CITY OF ALBUQUERQUE  
PLANNING DEPARTMENT  
November 4, 2015  
DRB Comments

PROJECT # 1005224

APPLICATION # 15-70392

RE: Lots A1A & A1B, Lands of Salazar Family Trust

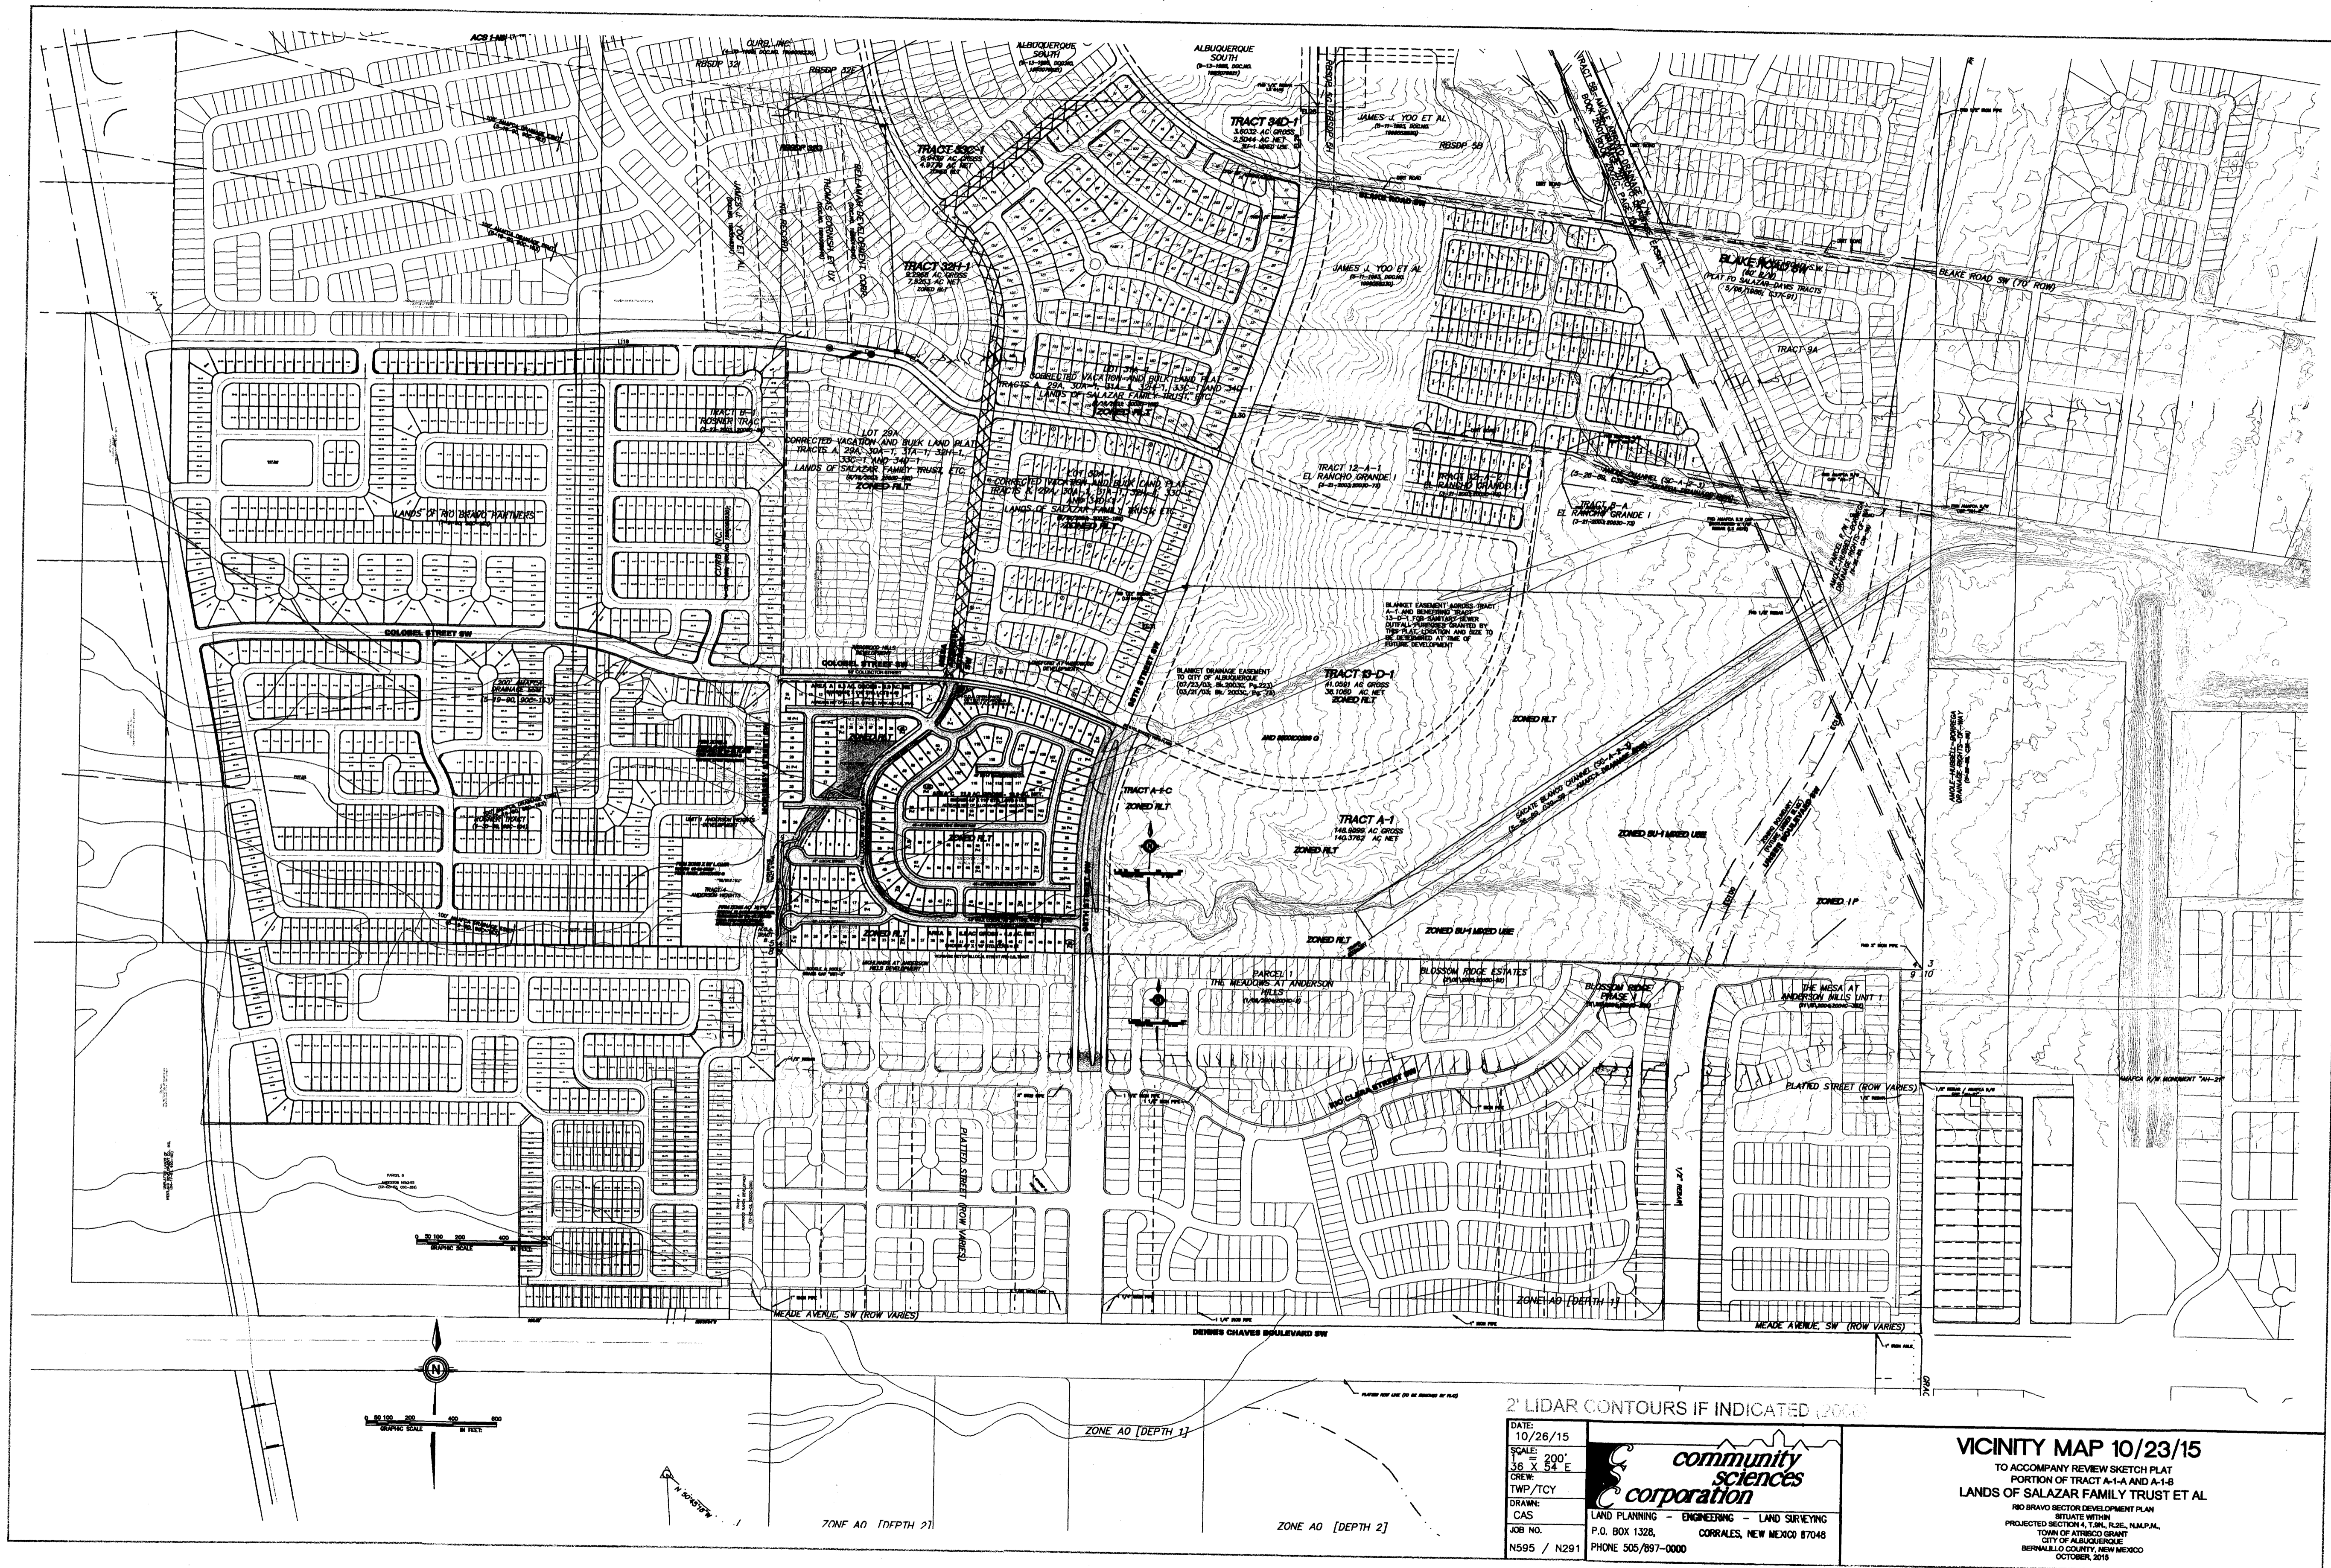
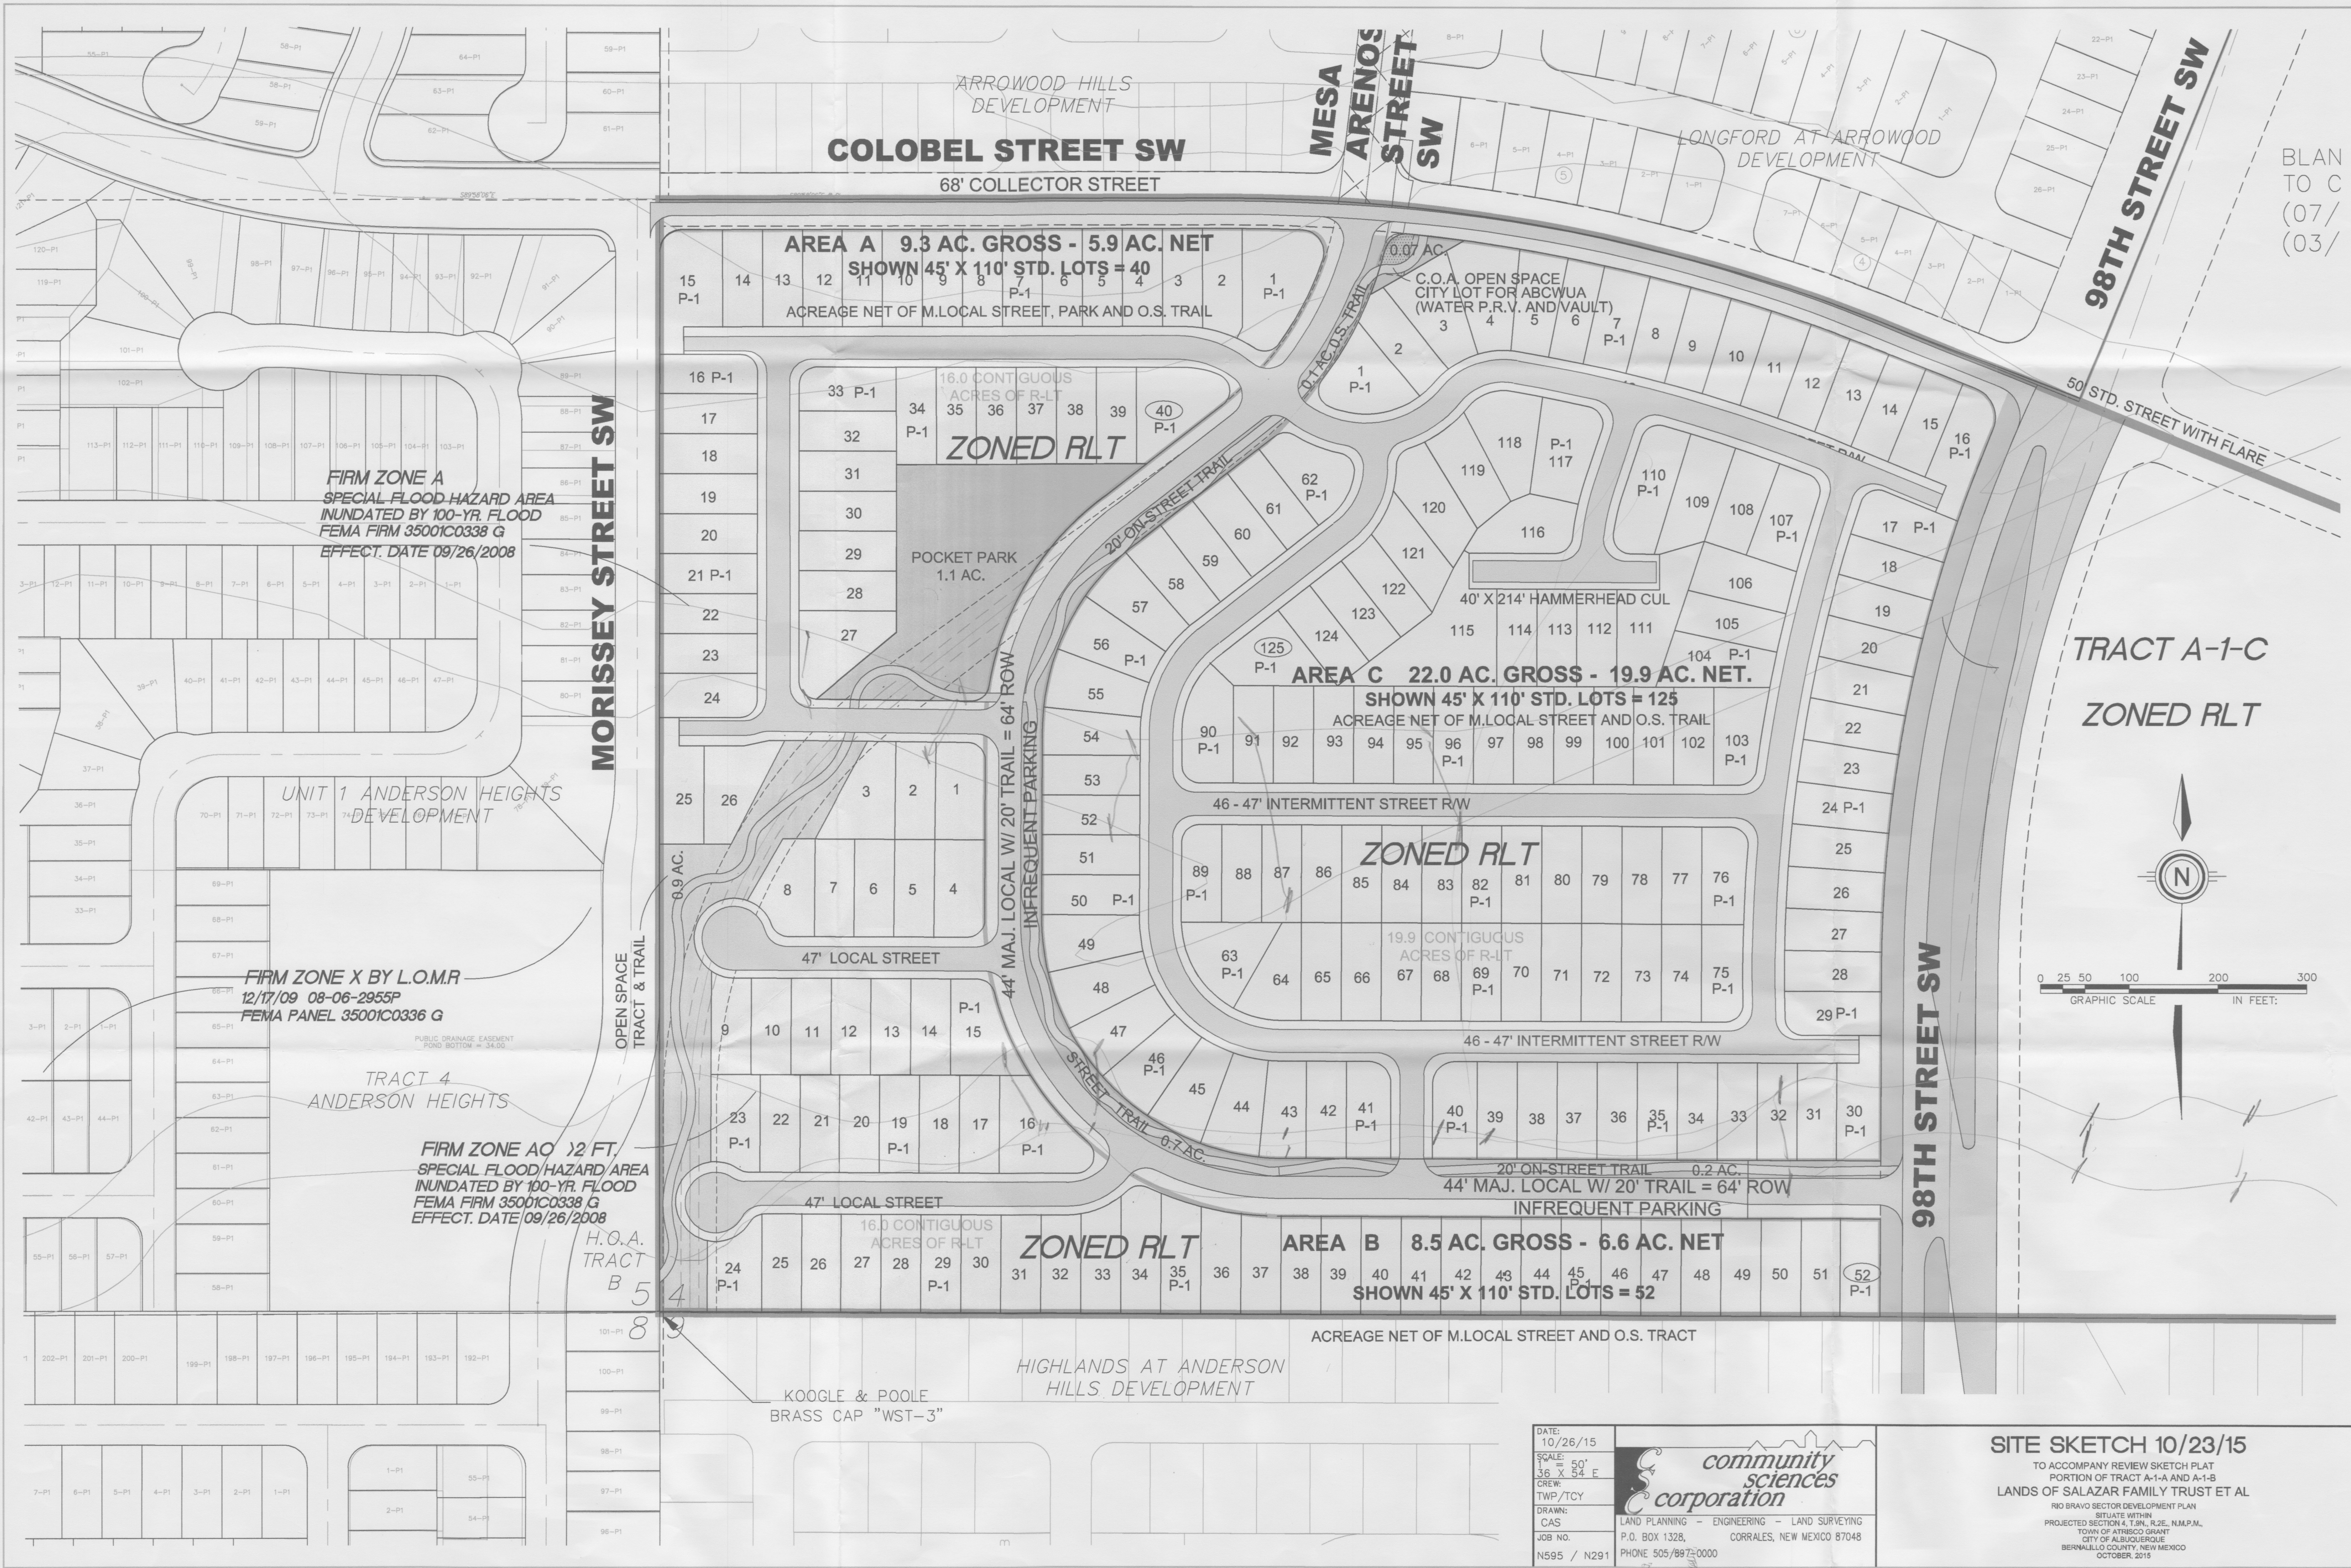
Refer to comments from Transportation Development; some Subdivision Design Variances appear to be required, particularly for block lengths and proposed hammerhead.

Discussion may be needed with the Urban Design and Development Division of the Planning Department regarding sector plan requirements. The proposed "product" seems similar to other contiguous development, and may require modifications.

An approved grading and drainage plan must be on file prior to Preliminary Plat approval.  
This project will need an infrastructure list.  
The City and AMAFCA would prefer that the Sacate-Blanco Channel property be declared surplus and combined into the property between Unser and 98<sup>th</sup>.  
A drainage master plan for the entire basin is required.
